From: Amanda Scholes on behalf of Planning.Responses
Sent: 23 November 2020 08:05
To: Planning Scanning
Subject: FW: WA/58/20/DOC - Condition 8 Electric Vehicle Charging Points
Attachments: 54_17_104_A Electric Charging Points.pdf

WA/58/20/DOC - Condition 8 Electric Vehicle Charging Points

ELEC VEHICLE CHARGING POINTS

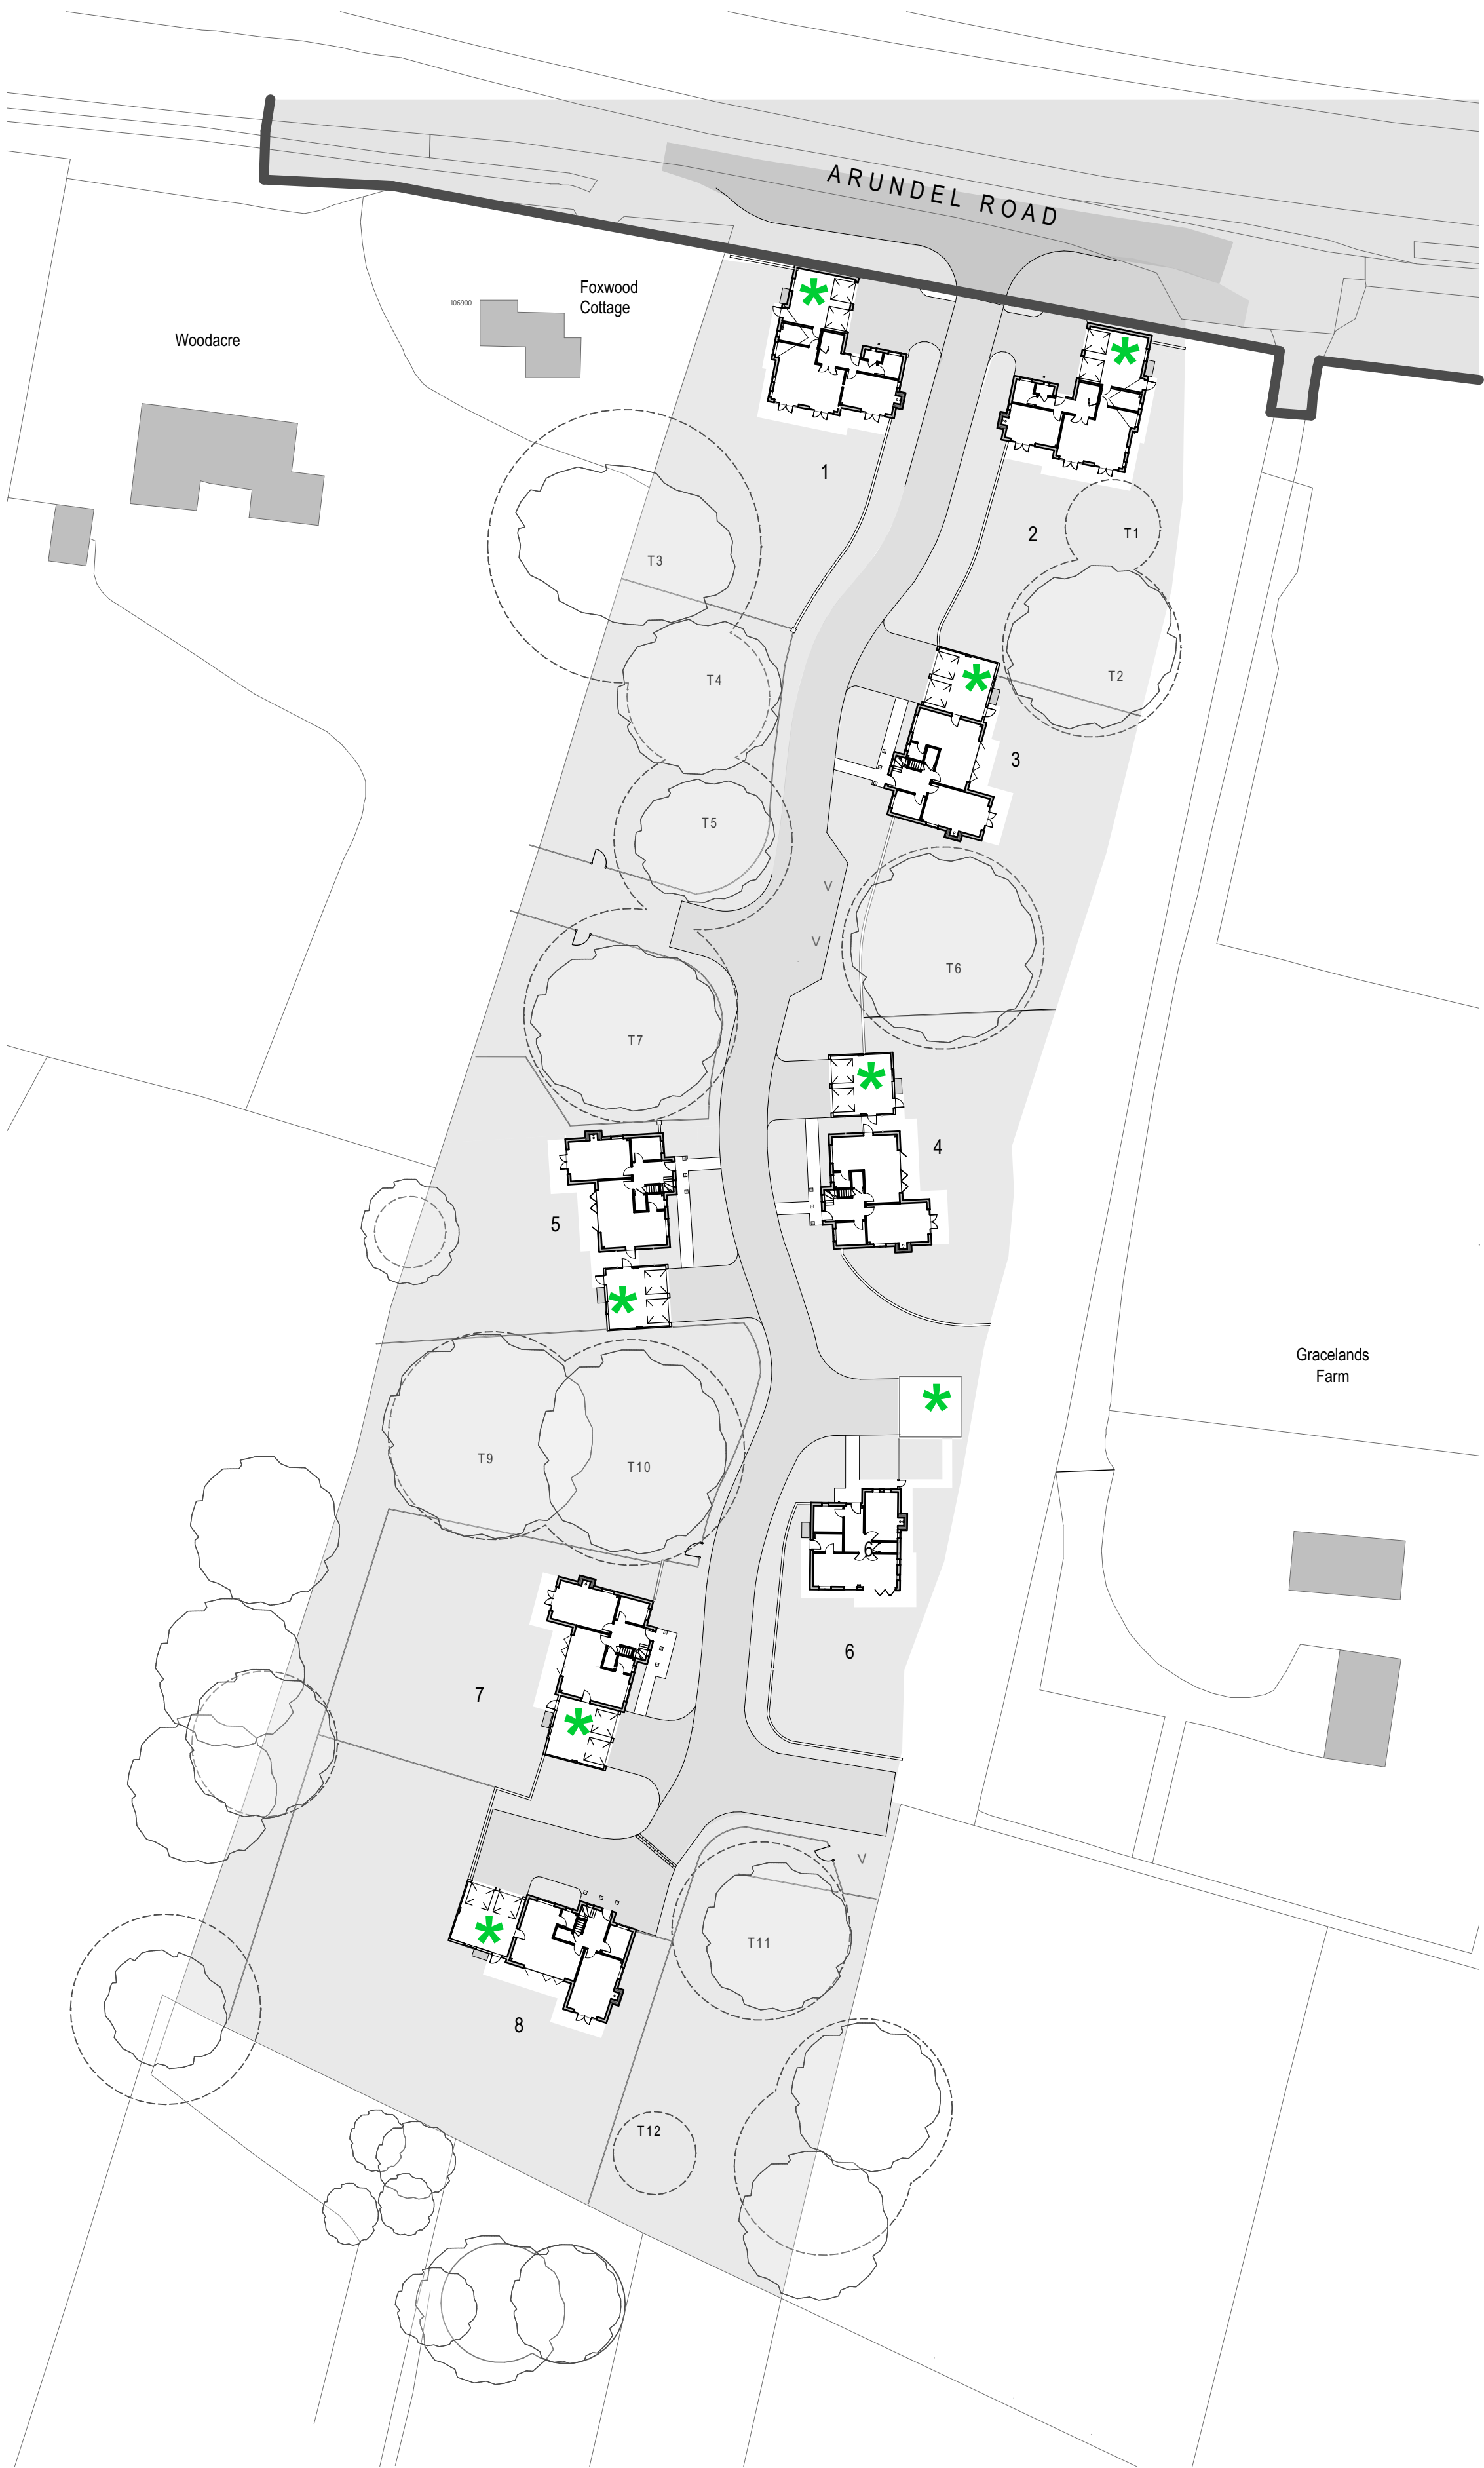
Ian,
I am not quite sure where you are up to. You may wish to withdraw this application. If not we need actual details of the EV charge points.

Please find attached updated drawing, now with the following note;

Socket for the provision of electric car charging.

sockets to be wired with 10mm twin & earth supply cable direct and including 40amp circuit breaker from the consumer unit to the position as indicated on the drawings.
This installation is to ensure that the occupants can install their own 32amp single car charging point or double if they wish at a later date using this pre-wired installation and appropriate circuit breaker.

This is a specification we have used on other recent projects and allows a degree of flexibility to occupiers whilst ensuring the infrastructure is in place to allow for the increased demand of a charging point.
